From: Simon Davis
Sent: 26 March 2018 12:47
To: Planning.Responses
Subject: FW: 90 Rose Green Road AW/333/17/DOC

Further Drainage Engineer comments

From: Paul Cann
Sent: 26 March 2018 12:45
To: 'Jonathan Simmonds'
[REDACTED] Simon Davis; Stuart Wilson; Laura Gibbons
Subject: RE: 90 Rose Green Road AW/333/17/DOC

CATCHPIT CHAMBER DETAIL
(Scale 1:20)

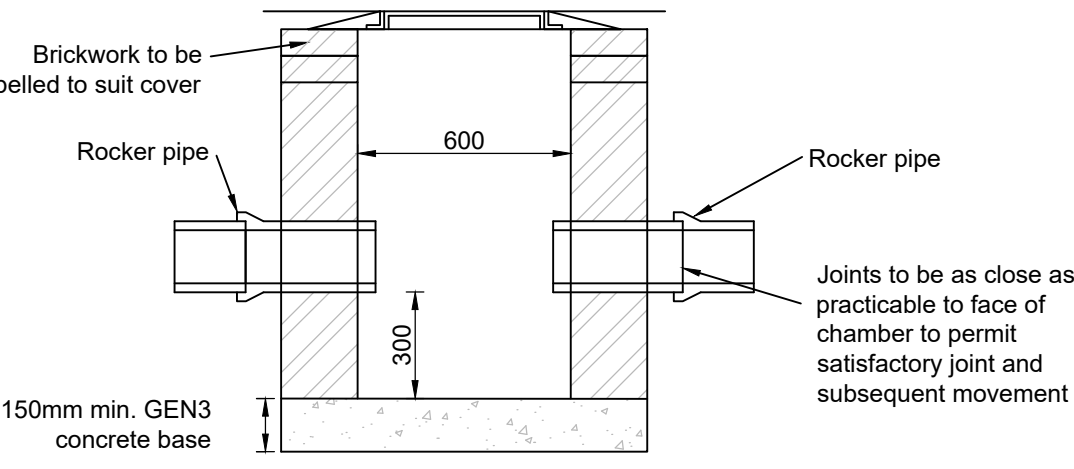
1. In terms of the potential for overland flows from the fields to the north, I appreciate that properties will not flood internally and that these overland flows will ultimately end up in the onsite suds system via the gullies. There may therefore be times in extreme events when the capacity of the suds system is compromised, and this may result in ponding around the site but should not affect properties internally. However, It is important that these potential overland flow routes are identified on your layout drawing, are considered when establishing finished levels, and that they remain in perpetuity for the lifetime of the development. Please add suitable notes etc to the drawing to cover this.
2. The catchpit chamber requires a 600mm cover as previously requested.
